Sent: 10 May 2012 13:36
To: Planning
Subject: URGENT: FAO Mr Laird re 6 plans for Fordwich Road

I live at number 8 Fordwich Road, and the proposed extensions are for building work at 6 Fordwich Road, which is occupied by Mr and Mrs White.

**DRAWING TITLE**  
PROPOSED SINGLE STOREY SIDE  
AND REAR EXTENSIONS

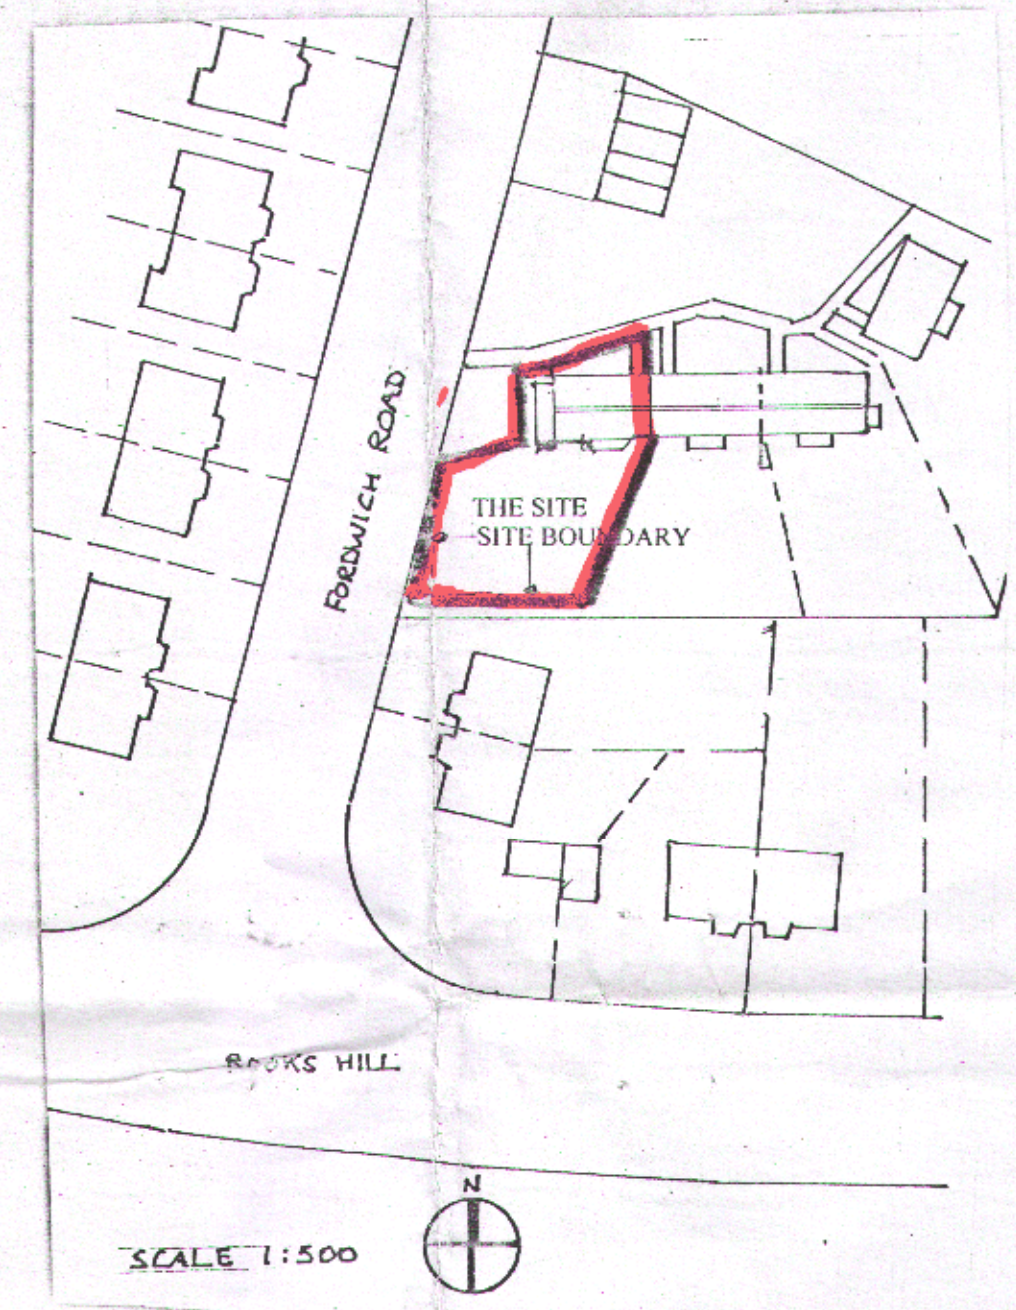
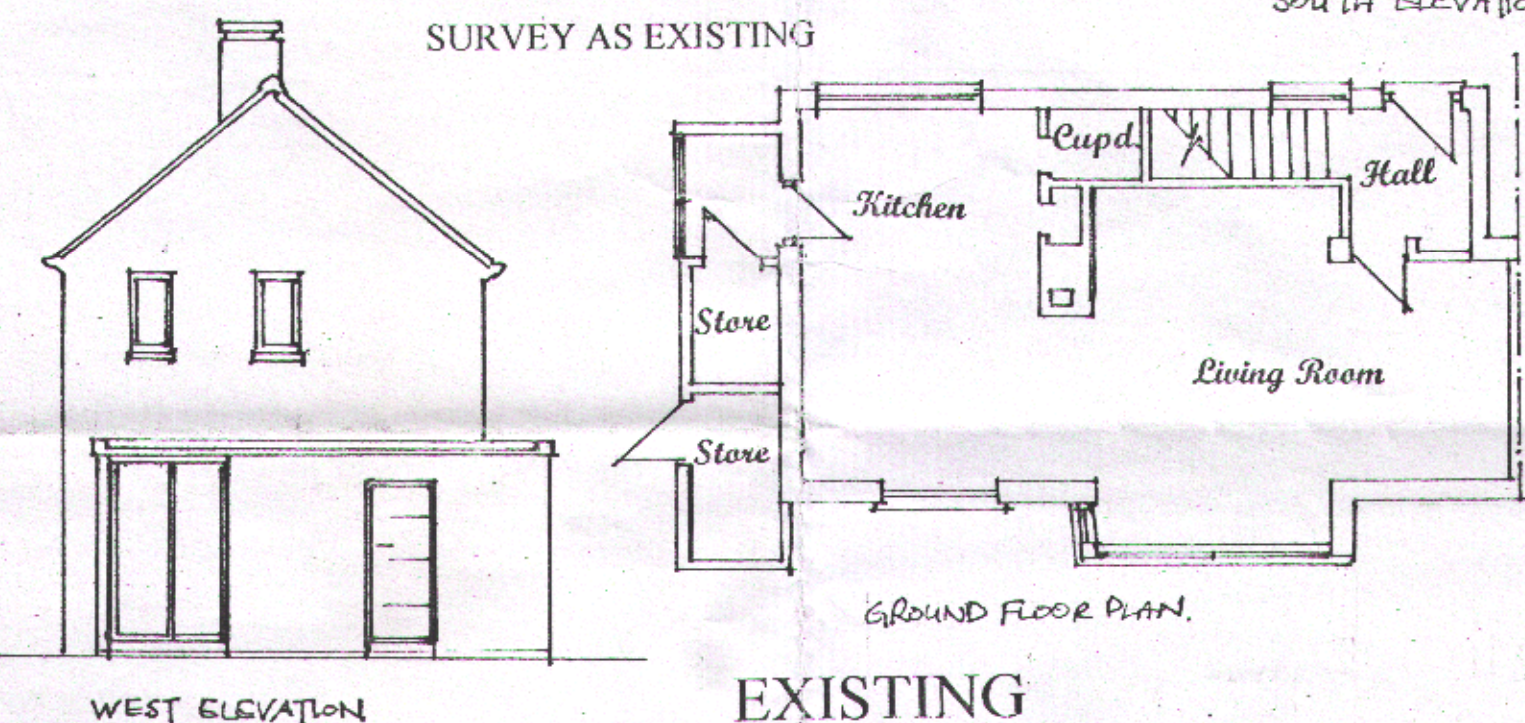
I object to these plans as they extend beyond the boundaries of the property on the west side, into the area of land that is a shared amenity for the 4 properties and not the exclusive property of the Whites. This would mean an unacceptable loss of amenity to the other 3 properties.

The boundary fence around the property does not extend for the 3 metres that they would need in order to build the proposed extension. The proposed extension, if built, would mean that the Whites have no longer any side access to their property and this would make a lot more demands on the main access to the building. Considering that there has been a long standing neighbour dispute, this would affect relations for the 4 properties.

The proposed extension would jut out well beyond the current boundary fence for that property. The scale of this proposed extension would mean that the house would be out of character with the rest of the neighbourhood and would result in a considerable loss of the visual amenity for the four properties in the scheme.
